Rezoning Transportation Analysis

Petition Number: 2023-027

Date	Description
06-28-23	First Review (PDM)

TECHNICAL DATA SHEET

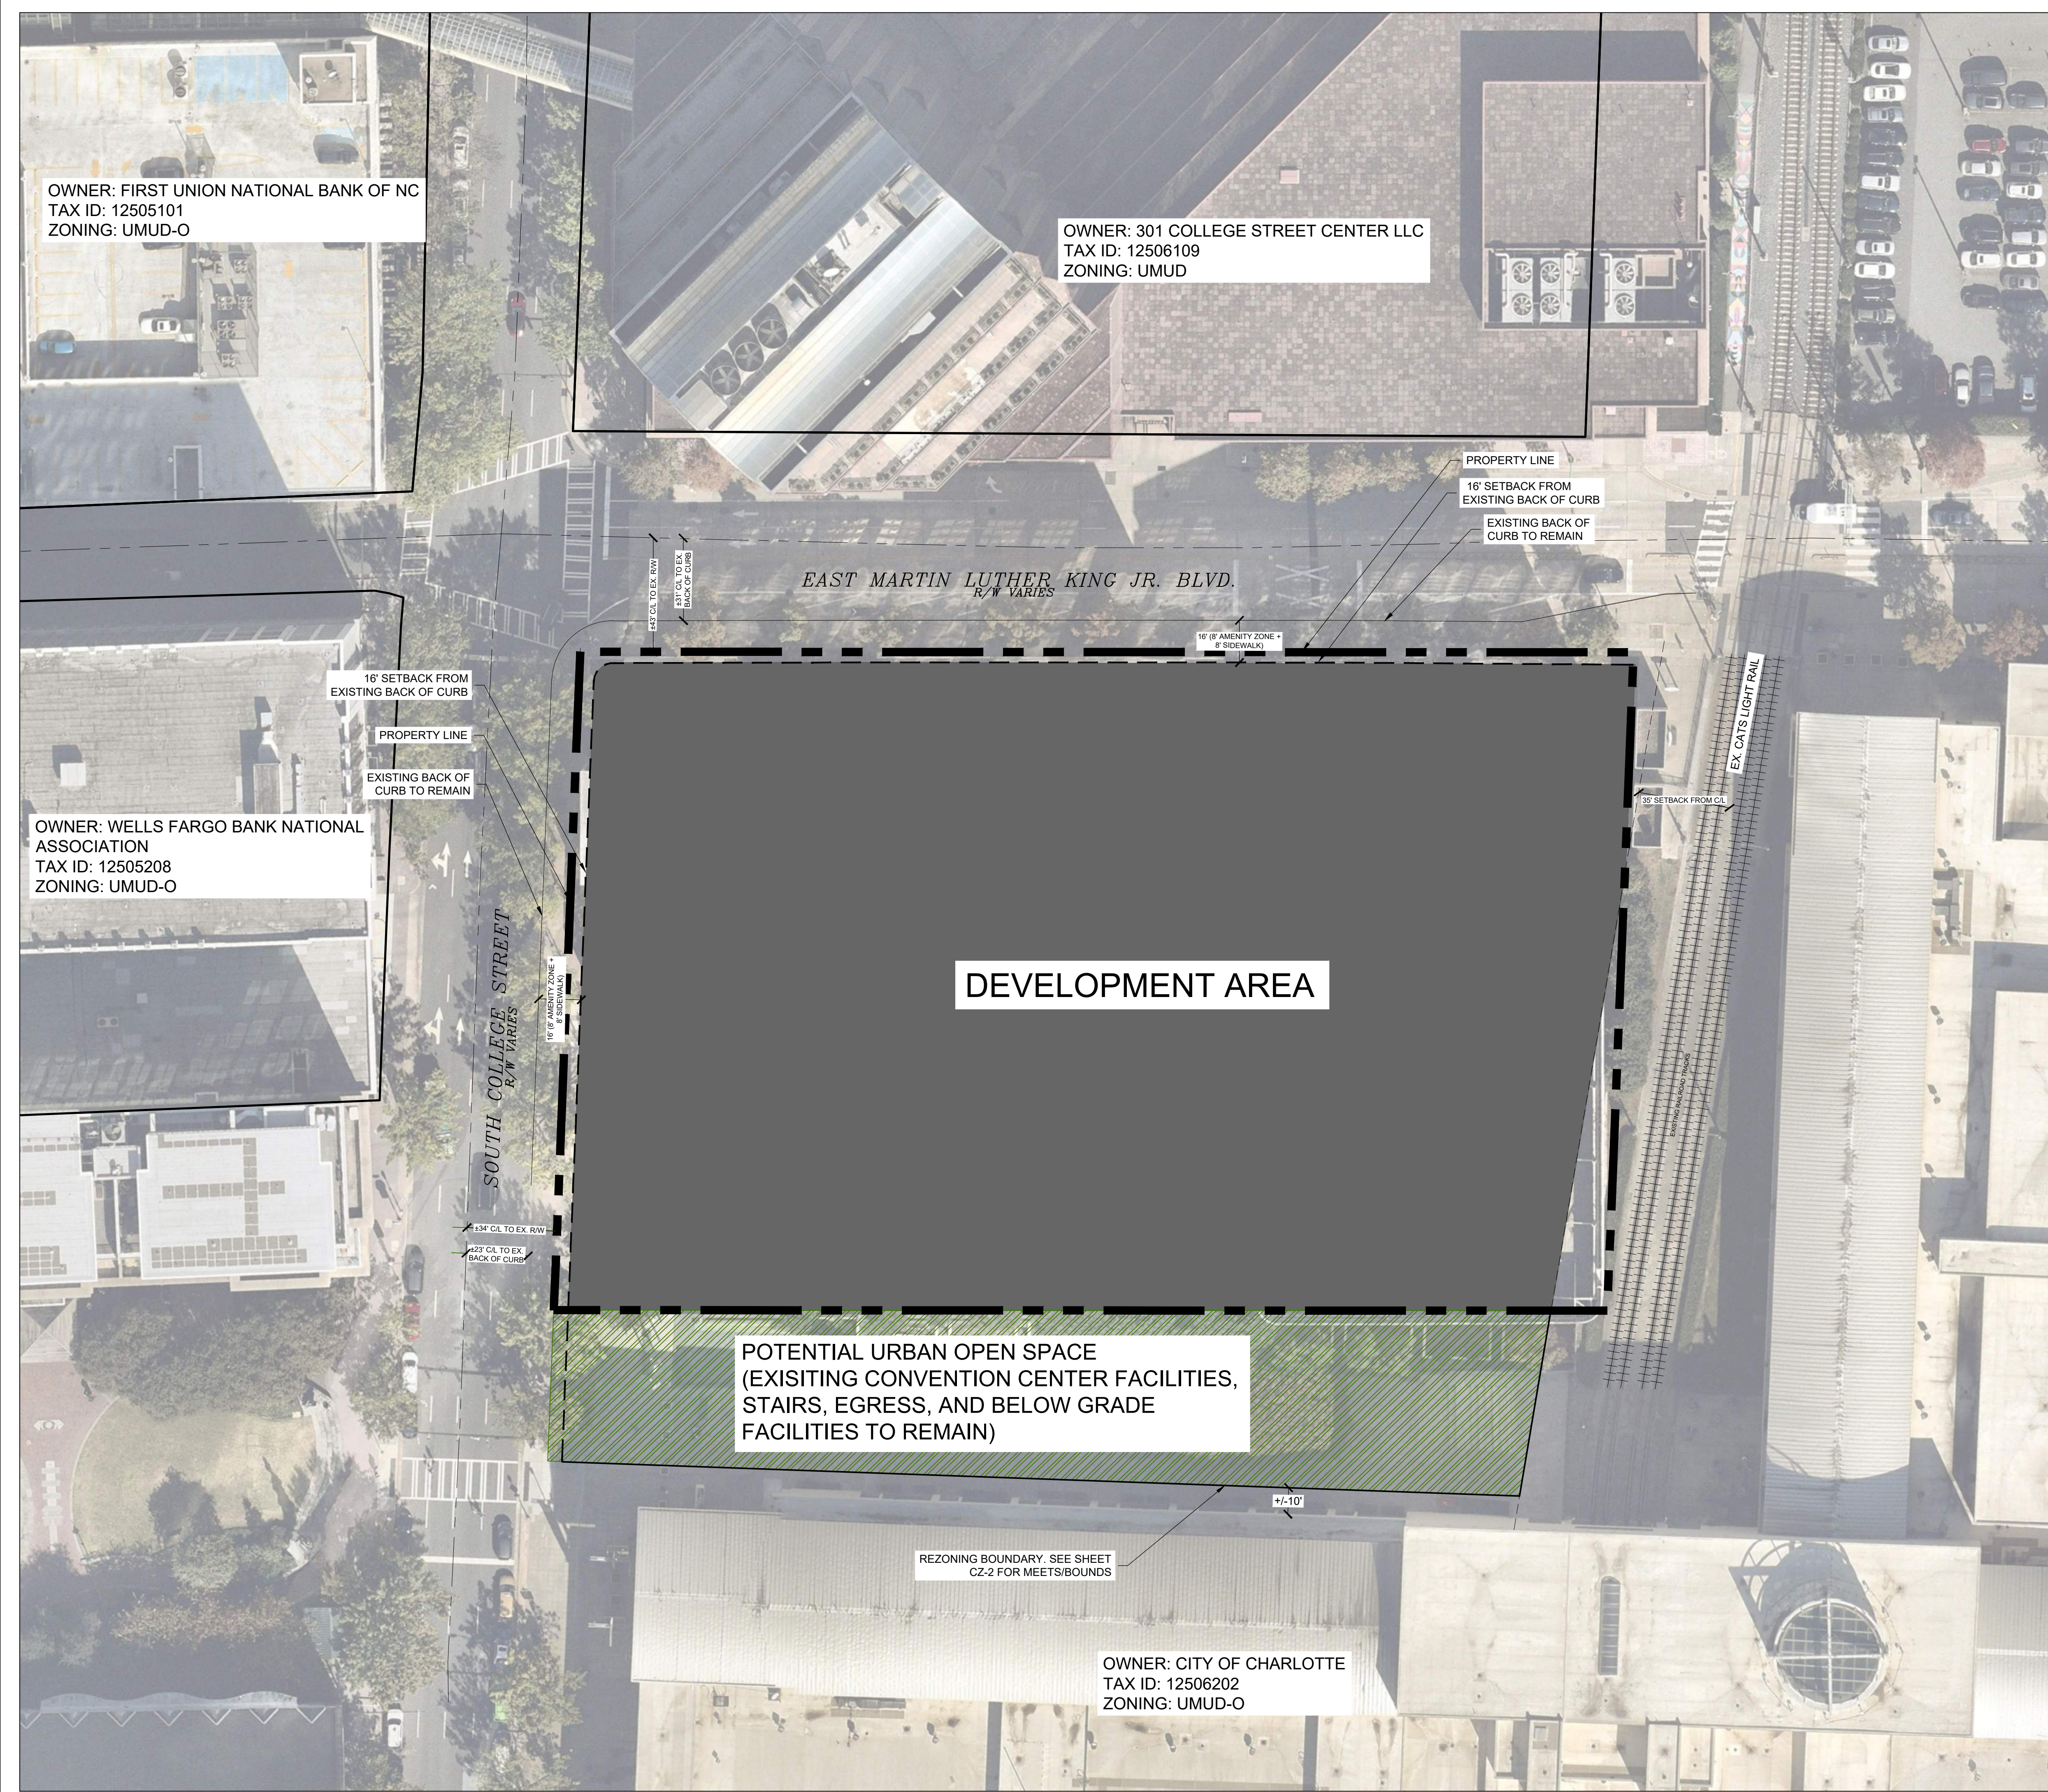
Label and dimension the curb and gutter from the centerline for each road on the site plan.

- 3. Revise site plan and conditional note(s) to commit to dedicate 40-feet of right-of-way from the road centerline on College Street. The site plan shall label and dimension the right-of-way from the road centerline. In addition label and dimension the right-of-way on Martin Luther King.
- 4. Add a conditional note specifying "A Right-of-Way Encroachment Agreement is required for the installation of any non-standard item(s) (irrigation systems, decorative concrete pavement, brick pavers, etc.) within a proposed/existing City-maintained street right-of-way by a private individual, group, business, or homeowner's/business association. An encroachment agreement must be

5. Revise site plan to show the proposed sites access locations and types.
6. Add a conditional note to commit to coordinating the design with the Uptown Cycle Track team to not preclude the installation of the future Uptown Cycle Track.
7. Revise site plan and conditional note(s) to commit to installing a Rail Trail connection to Martin Luther King Boulevard.
